SSDA Response to Submission (RTS)

St. Luke's Grammar School

New Senior School Campus

800 Pittwater Road, Dee Why NSW 2099

1 ELEVATION WEST
1:200

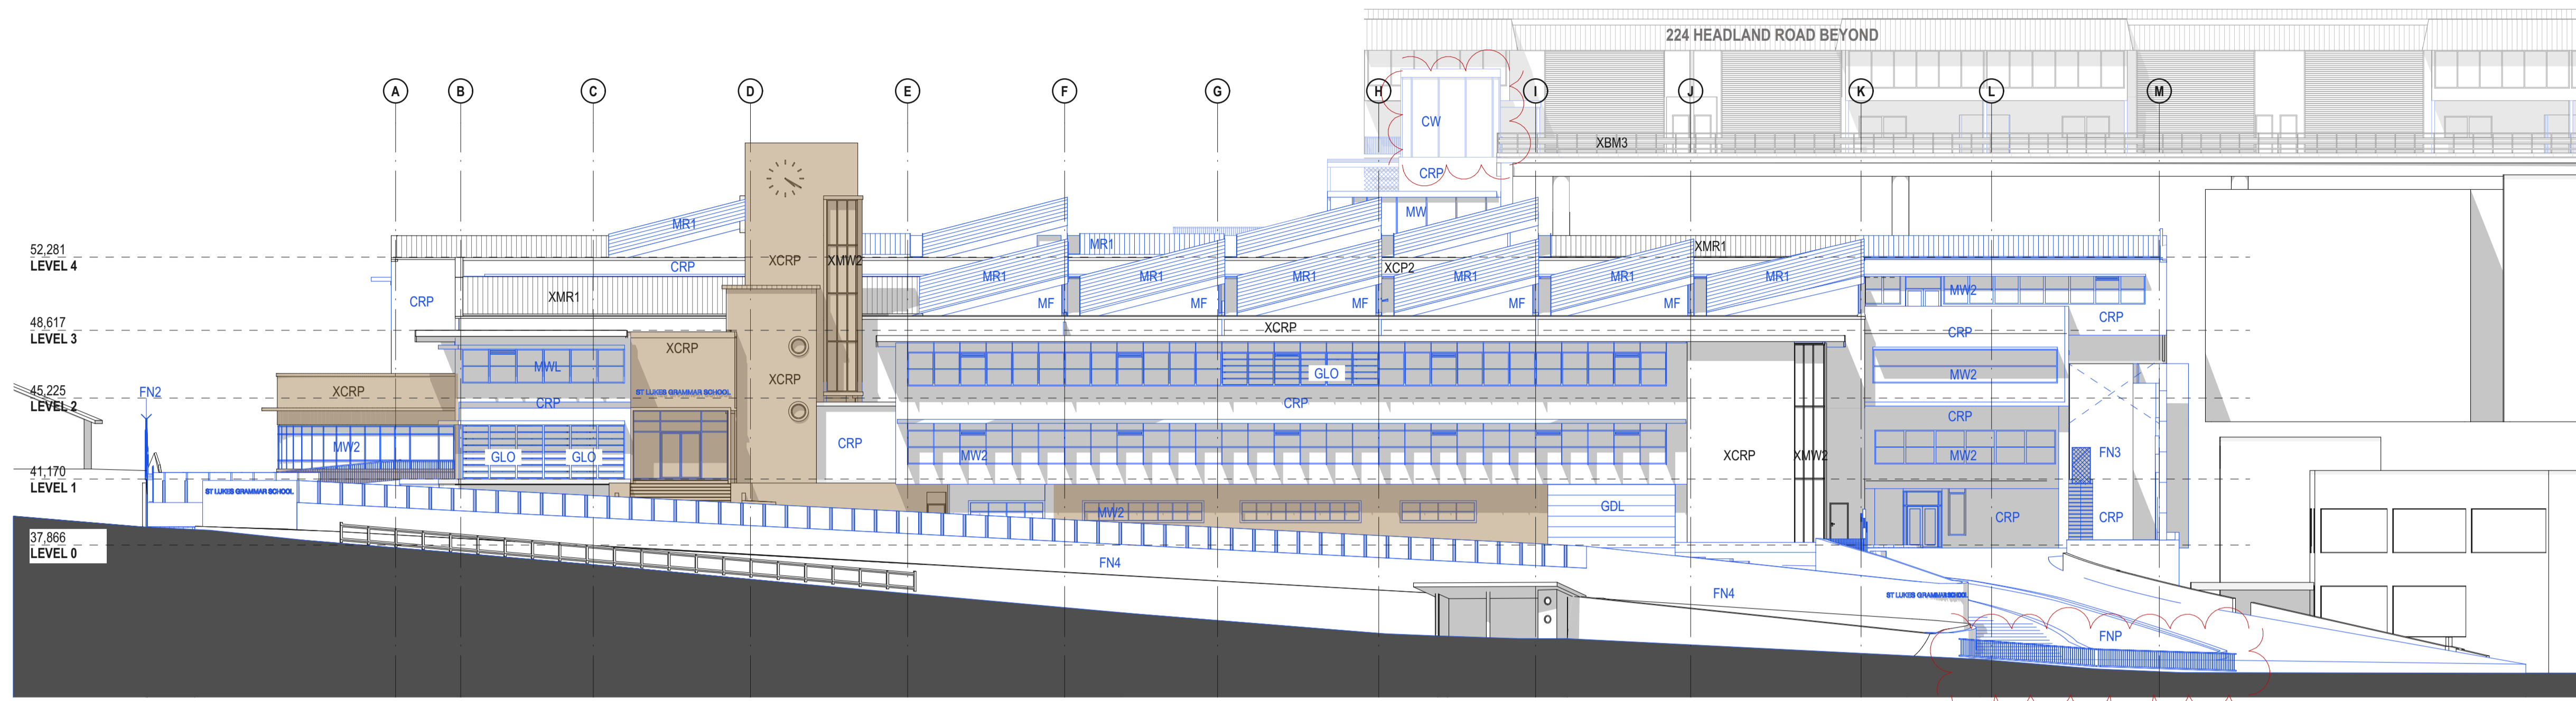
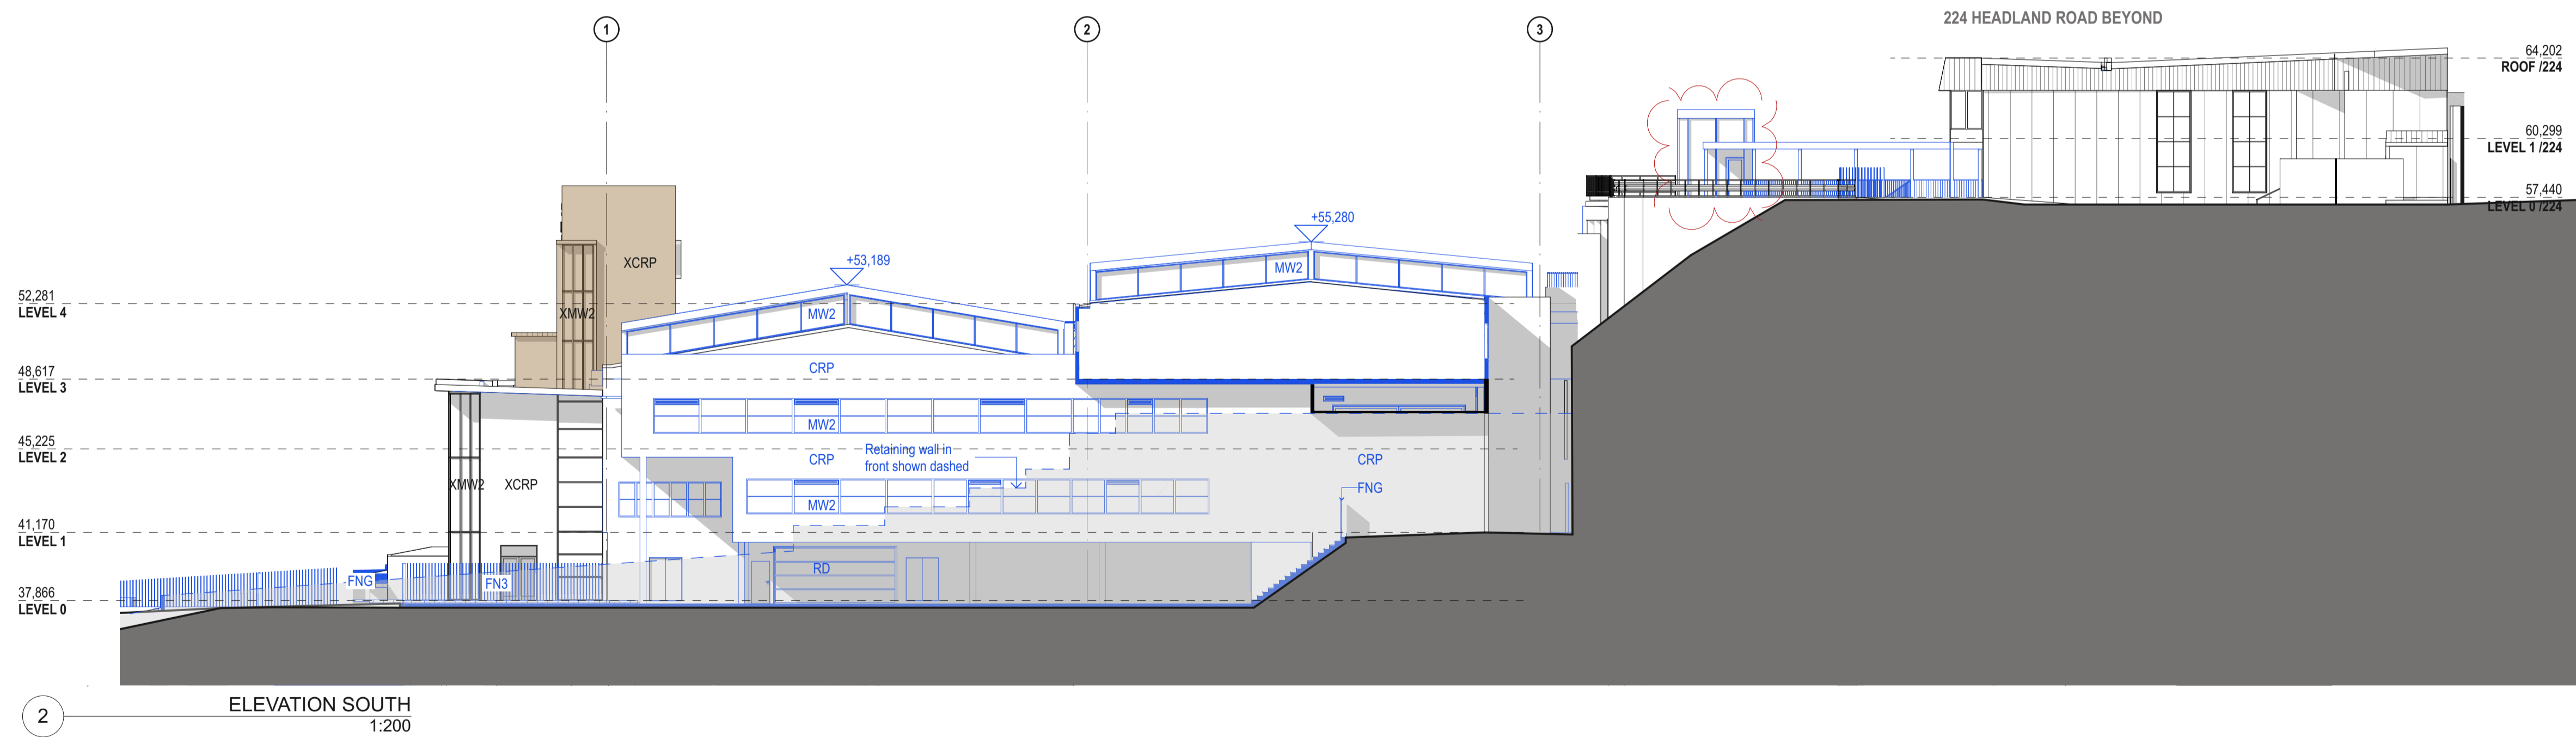
The new design fails to interpret the solidity and fenestration pattern of the original facade. The existing glazing on the western facade is proposed to be replaced with a new facade of solidity and fenestration which is not a lot different than the existing in terms of the location of the external walls. The original facade was located behind the leading edge of the clock tower with a parapet and recessed upper storey facade as well a large overhang. Similarly, the area to the left of the main entrance was also behind the leading edge of the tower. This original design ensured that the asymmetrical clock tower and building entrance took prominence as part of the original design, which has been lost in later additions. While the proposal does adopt a strong horizontal architectural statement, by adopting the line of the current Officeworks building for its new walls and large overhangs, this component will continue to

affect views to and from the clock tower. It would be preferable if the overhangs are removed and the upper section on the southern end recessed, thereby reinstating the original parapet wall. This will help to interpret the solidity and fenestration and the articulation of the original fabric. Slightly recessed glazing behind this parapet wall could complete the second storey. By doing this the proposed second storey area will need to be reduced (a reduction in the size of the proposed atrium may be considered to regain the required internal area). The original colonnade on the ground floor should be reinstated. This again will result in a slightly reduced internal floor area but will help the building to regain its original fabric on the western facade. A similar design approach should apply to both sides of the main entry on the western facade, so as to retain the prominence of the tower element and also retain significant views to the tower and to the semi-circular canteen element at the north-west end of the building.

The Northern Beaches Council recommendation to reinstate the original parapet wall on Level 2 and the colonnade on Level 1, would require significant restructuring of fabric demolished in 1998.

The GFA loss resulting from the set-back of the western facade walls as per Council’s recommendations amounts to more than 500 m2.

To re-instate the original colonnade on Level 1, the administration area would have to be reduced by ~235m2 and the public foyer area would have to be reduced by ~22m2. The remaining floor area would be insufficient to fit the required accommodation.

To re-instate the original parapet wall on Level 2, the general learning areas (GLA’s) would have to be reduced by ~255m2, which will result in the loss of 5 GLA’s. This remaining GLA’s will be insufficient to fit the required number of students and does not meet the educational requirements.

The proposal is to interpret the original collonade columns by larger shading fins to mark the original location of the columns. The enlarged shading fins (highlighted in blue) are integrated in the array of shading fins along the new fenestration bands of the western facade.
